Fowler creek Ranch

CU-23-00003

EXHIBIT 16 - SITE PLAN - FOWLER CREEK GUEST RANCH

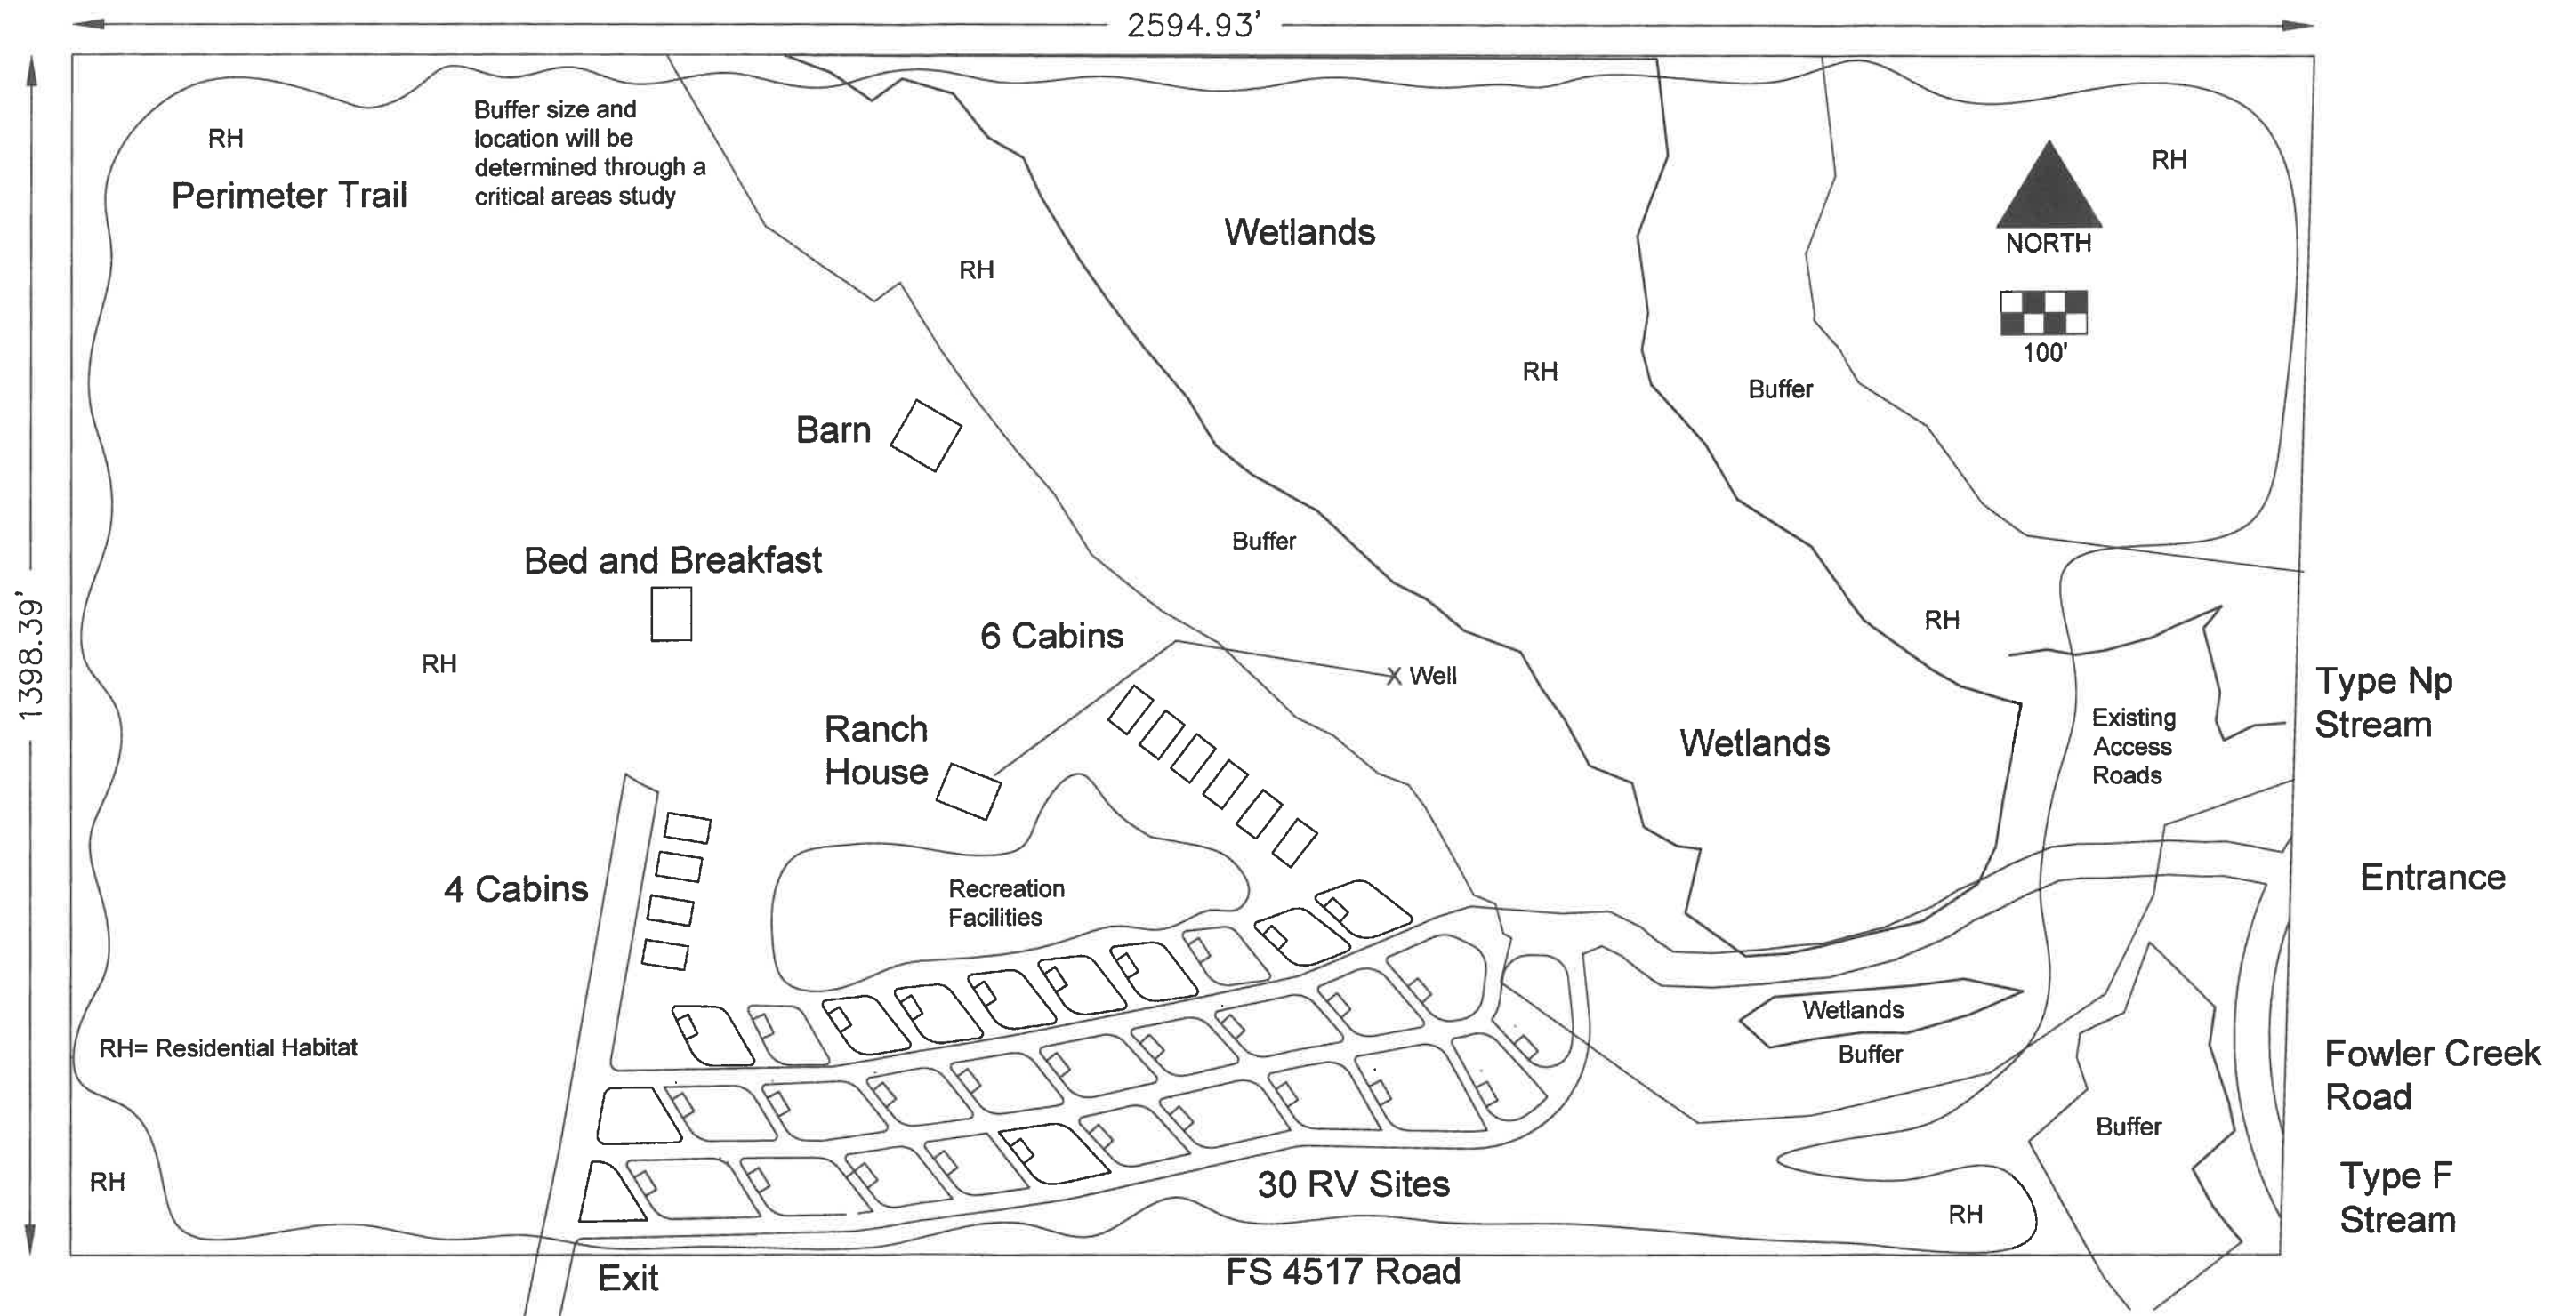
The map shows a well. How much water is he allowed. There two more pumps that are pumping water up Two Granite creek homes.

Who gave permission to build a dam to block up the water in the wet land? EPA or the county I never seen a SEPA report. The dam was built to keep his wells primed.

I dont see any plans for sewage of any kind for the amount of proposed cabins and camper spaces.

The existing roads on the south east corner are coming from my property. They are fire trails and used for local fire wood.
